WELWYN HATFIELD COUNCIL – DEVELOPMENT CONTROL
DELEGATED REPORT

APPLICATION No:	S6/2007/1766/FP
------------------------	------------------------

The proposed development would involve the demolition of the existing house and detached garage and the erection of a replacement house with an integral garage. The proposed dwelling would have a relatively low height with the first floor accommodation within the roofspace. The proposal would measure a maximum of 13.3m in width by 10.6m in depth with a crown roof to a maximum height of 7.5m.

Elevations of
Existing Dwelling

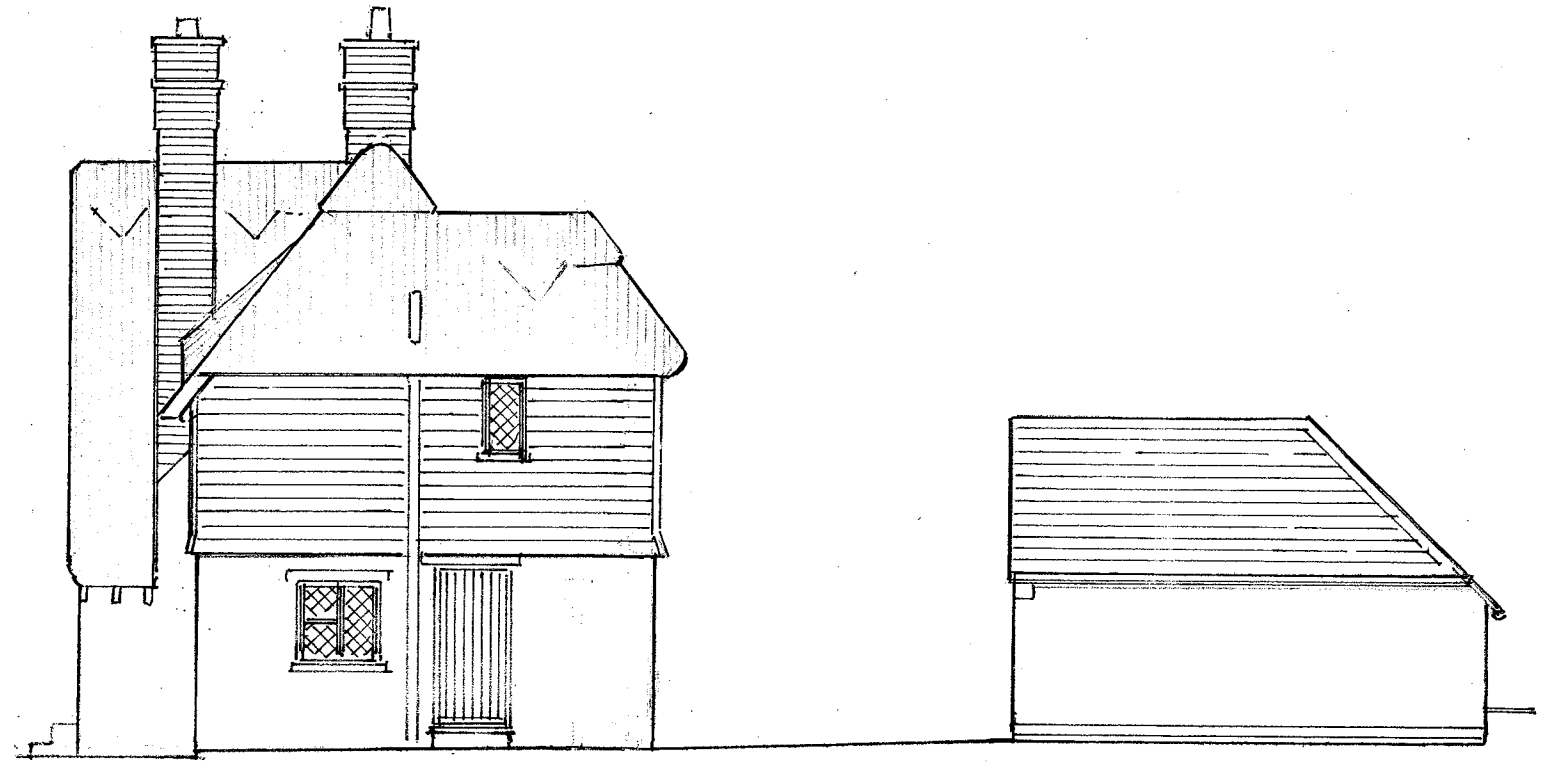
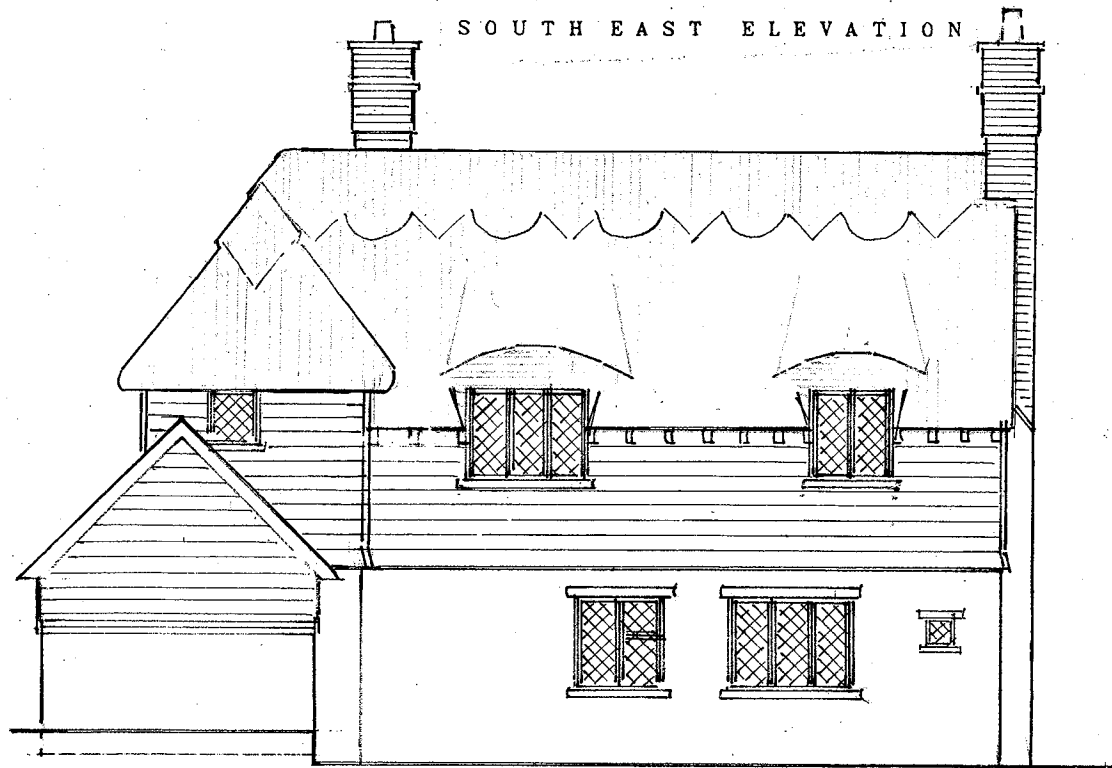
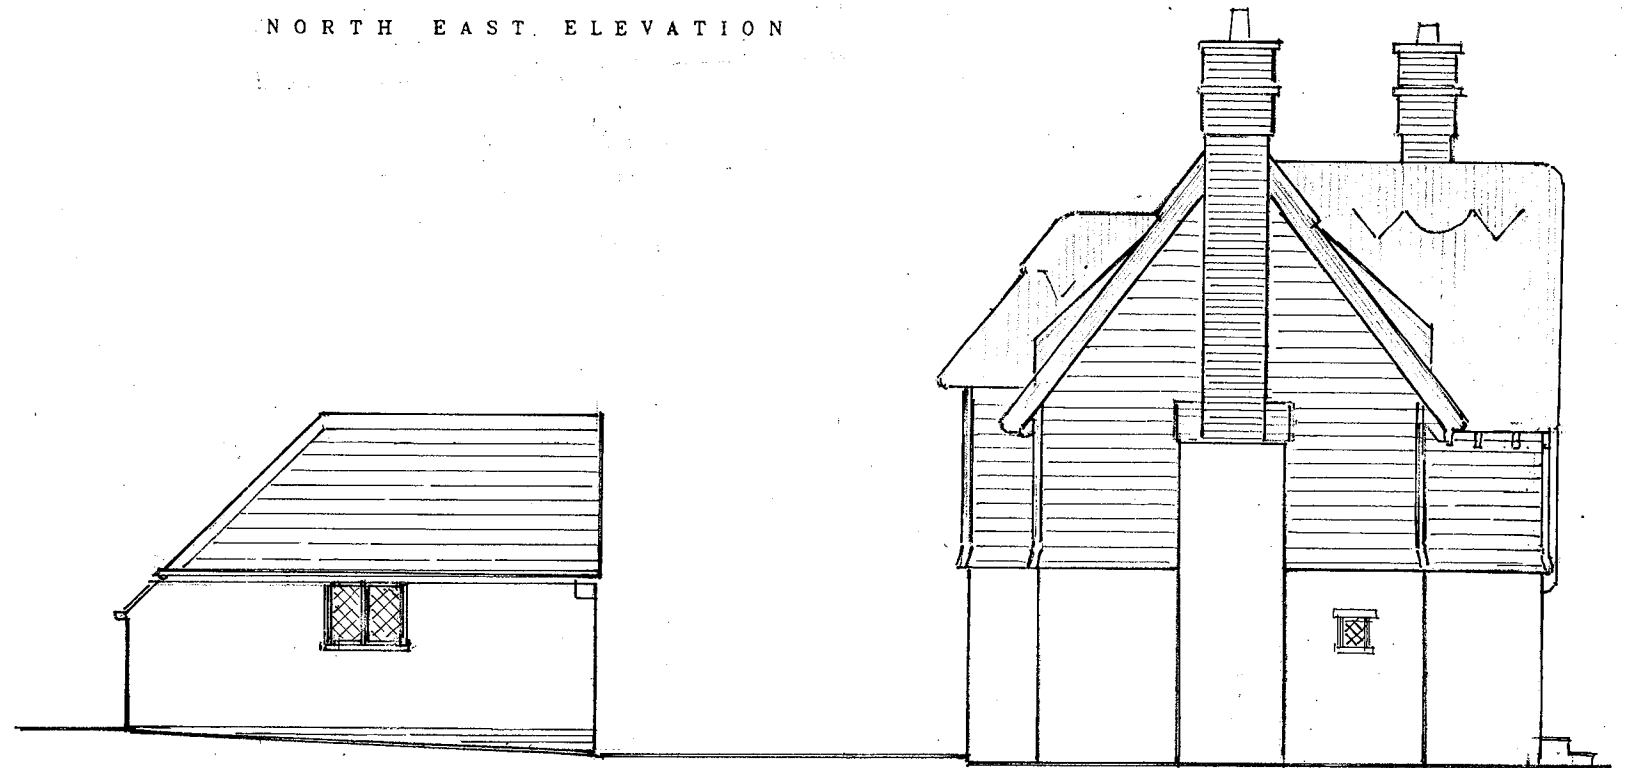
The existing dwelling is thatched, timber cladding and render. Although the dwelling has some charm and character, it is not considered worthy of protection and does not fall within a conservation area. Through a consultation with the previous application, English Heritage did not raise an objection to the demolition of the existing dwelling.

The proposed dwelling would have a maximum height 0.6m below the ridge height of the existing dwelling. Due to the variations in the street scene and distance between properties within the locality, the proposed eaves and roof height would be acceptable.

Date : November 2007  
Scales : 1 : 100 & 1 : 200  
Dwg No : A 747

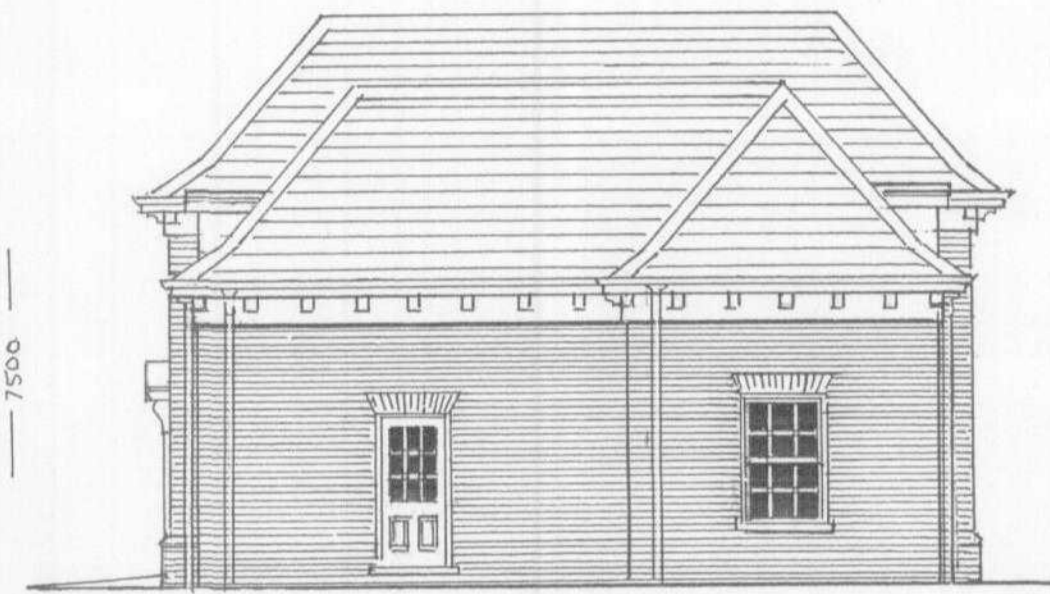
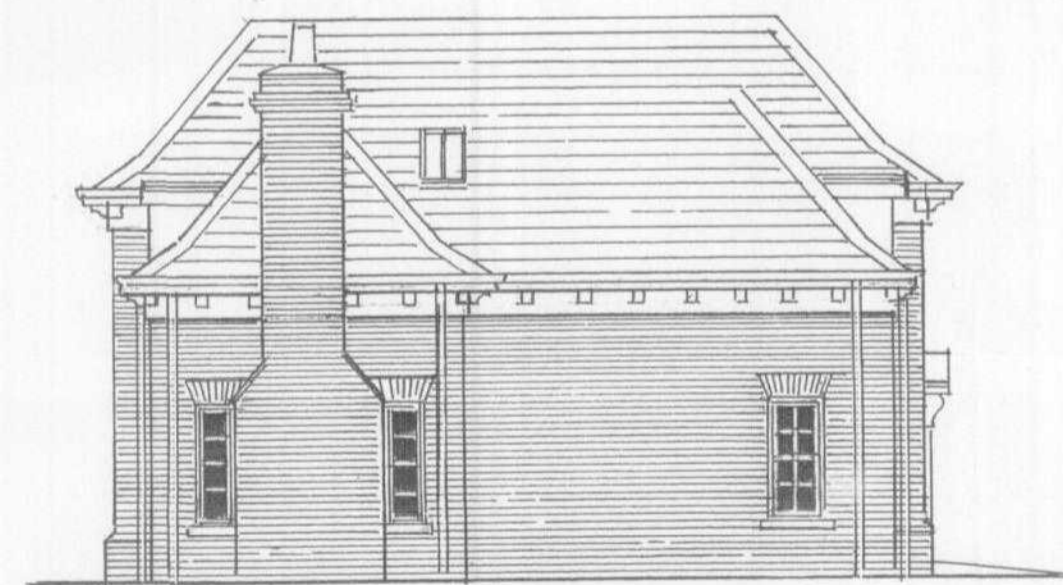
2. There are no proposed first floor flank windows and the proposed development would not result in any further overlooking. The adjacent property to the south west (no 35) is the closest dwelling to the proposal. Although the elevation facing number 35 would increase in depth, due to the separation distance between the two dwellings and landscaping to the boundary, it is considered that the replacement would not result in a detrimental impact upon amenity. The proposal would not interfere with a 45° line drawn from number 35 nearest window and would not result in a significant loss of light to this property. The distance to the adjoining dwelling to the north is such that there would be no impact. There are no properties within close proximity to the rear boundary and the proposal would not have any further impact upon this area of land. There would be sufficient rear garden space to accommodate private amenity area (measuring approximately 16 x 33 metres).

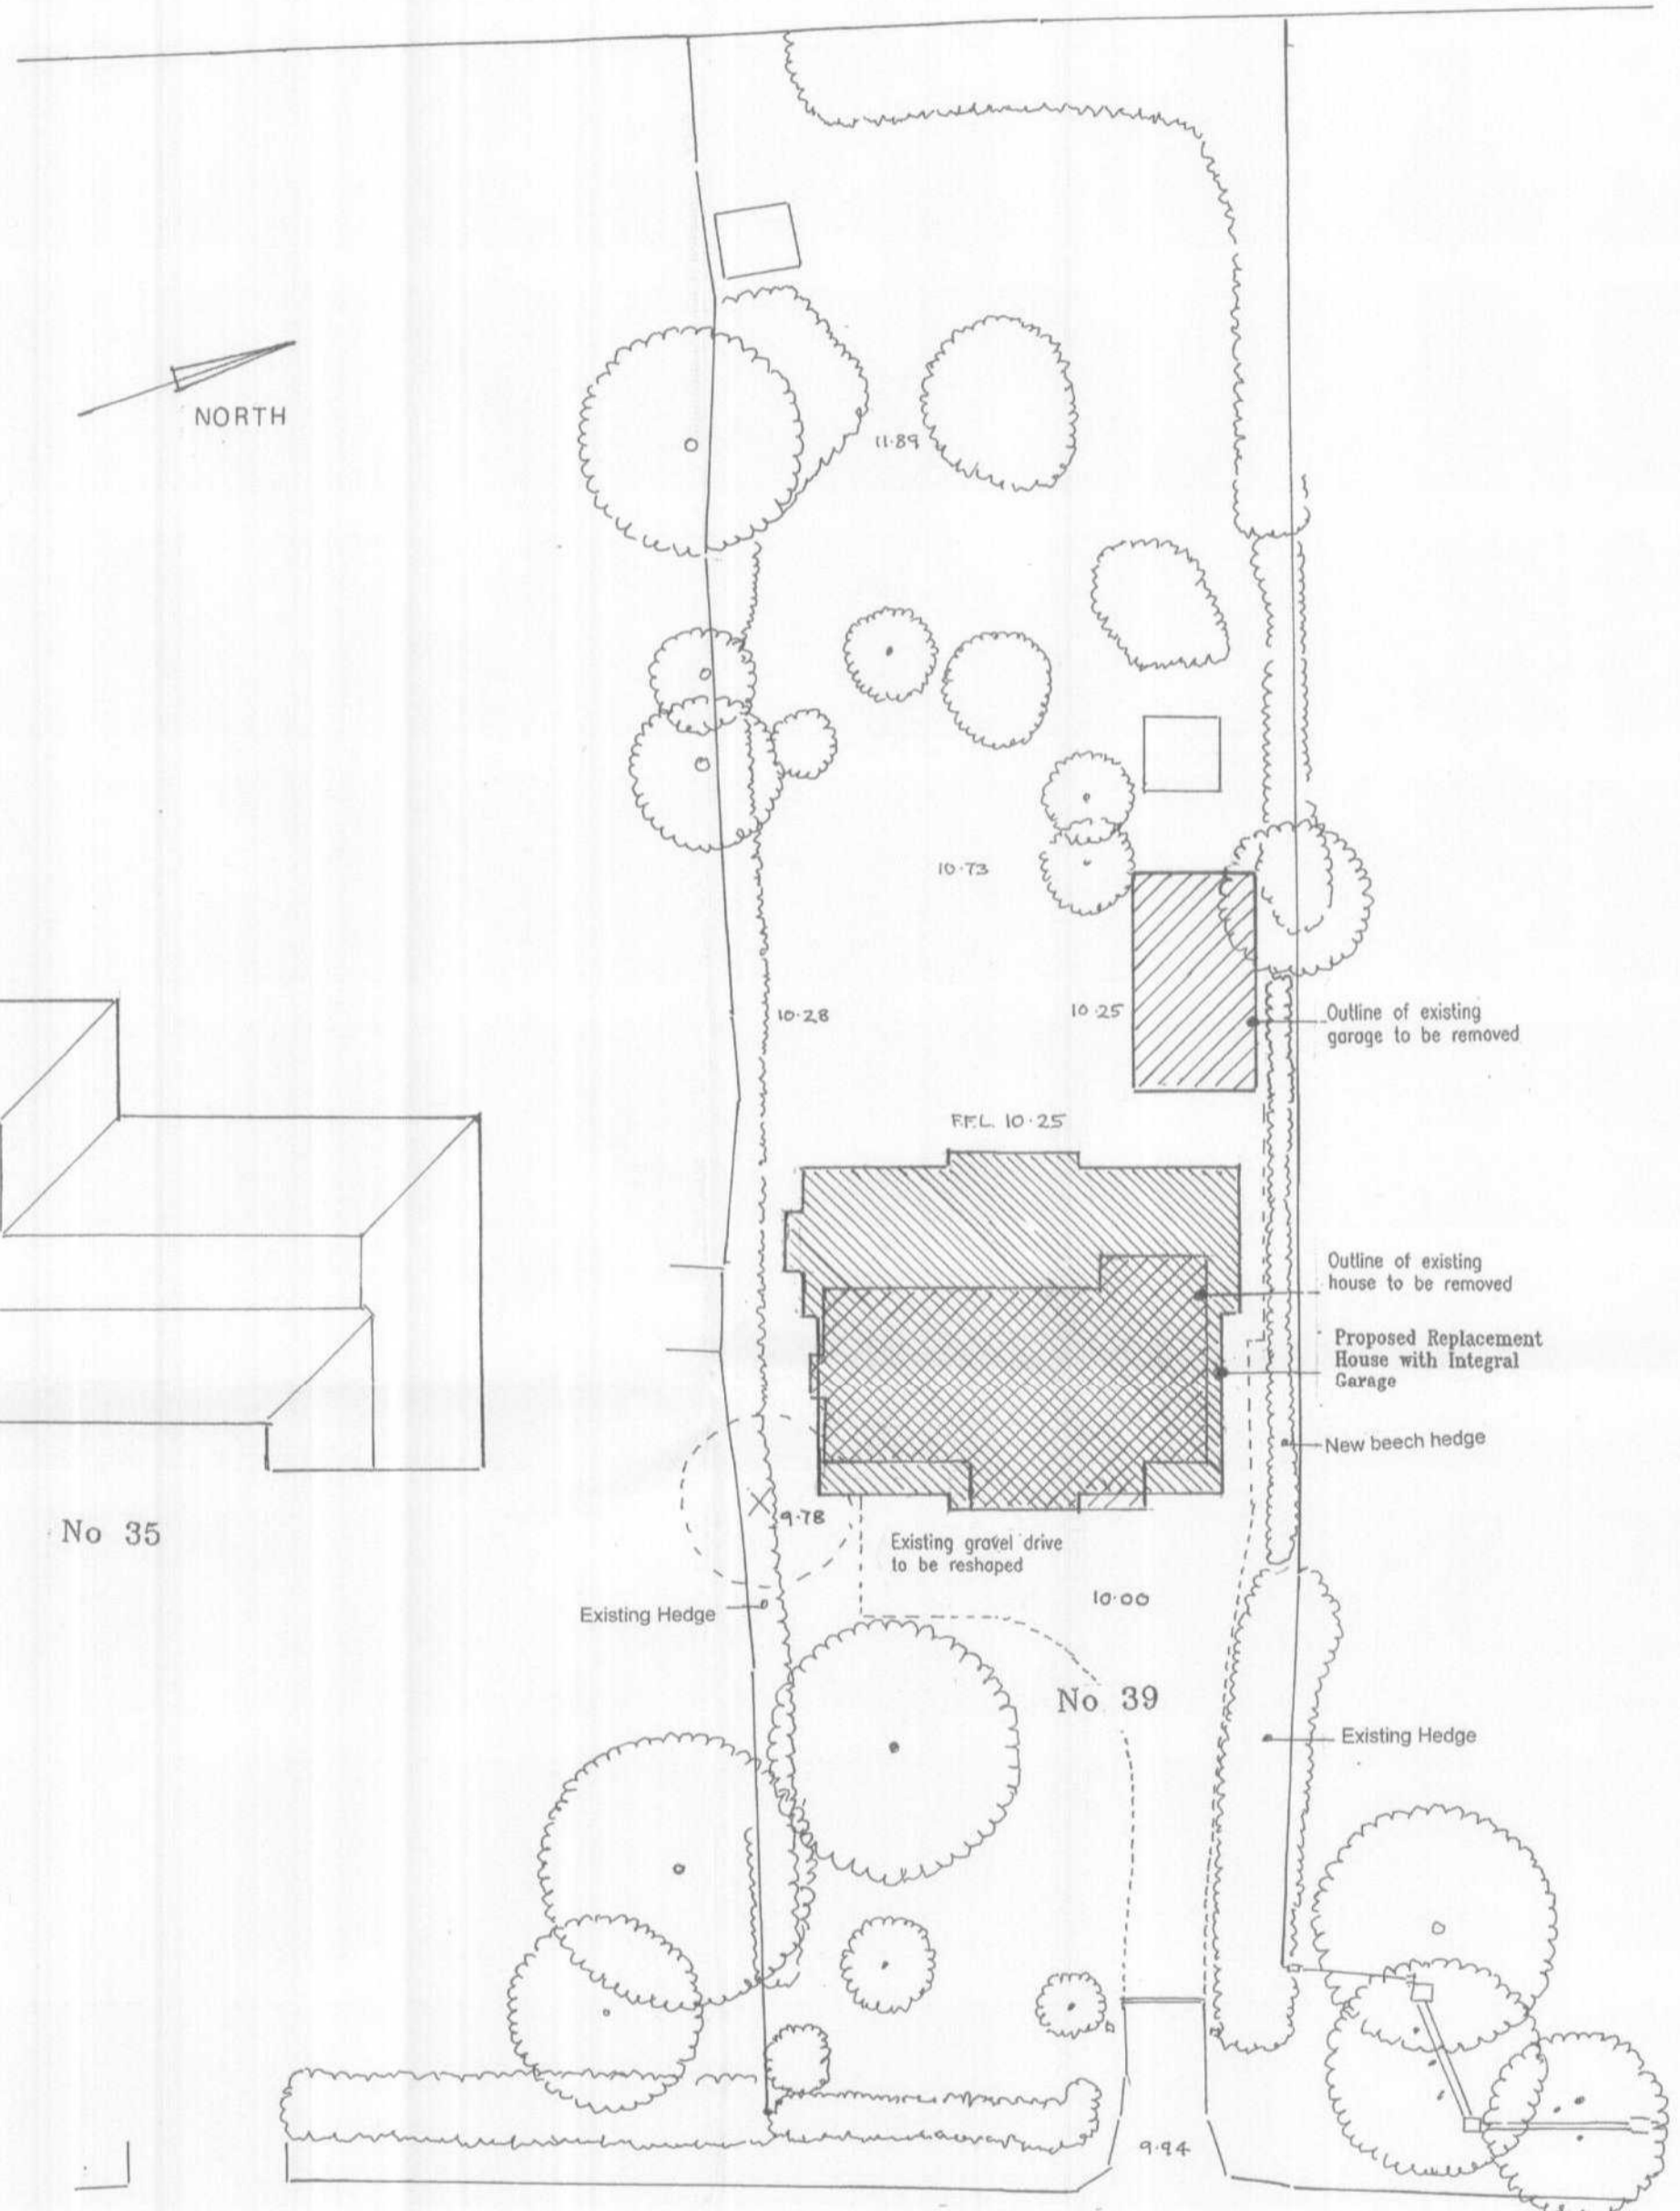
The proposed dwelling would be sited on a similar footprint as the existing dwelling and would not sit forward of the foremost position of the existing dwelling. The proposed dwelling would retain a distance of 19m from the front boundary, this distance would help prevent the proposed dwelling from appearing prominent within the street scene.

The proposed dwelling would retain an appropriate spacing from the flank boundaries of the plot. Although the proposed dwelling would be closer to the flank boundaries

than the existing dwelling the proposal would retain a low eaves level and not dominate the plot's width. The proposed distance to the flank boundaries would exceed the minimum of 1m as detailed with the Design Guidance and an appropriate distance would be retained between the application dwelling and neighbouring properties.

4. The application site falls within zone 4 as designated by the parking standards of the Welwyn Hatfield District Plan 2005. The application site would retain a large hardstanding to the front of the dwelling, which would be sufficient to accommodate off road parking space for 3 cars. The existing vehicular access would be retained

The proposal would result in removal of a tree near the south western boundary and a new beech hedge would be planted along a section of the north eastern boundary. This tree is not protected and does not make a significant contribution to the street scene. It is close to the existing building and not in an ideal position. Due to the proposed dwelling being sited on a similar footprint to the existing house, the proposal would not interfere with surrounding vegetation. The proposal would retain a sufficient distance from the mature trees and vegetation which make a substantial contribution and add to the character of the locality. It is therefore not considered to be necessary to insist on a landscaping scheme as a condition for an approval.

1. C.2.1 - Time Limit Full Permission
2. C.5.1 - Material to be submitted
3. The height of the dwelling hereby permitted shall not exceed 7.5 metres from the existing ground level and shall reflect the relative relationship of land levels and building heights identified on the submitted plans.
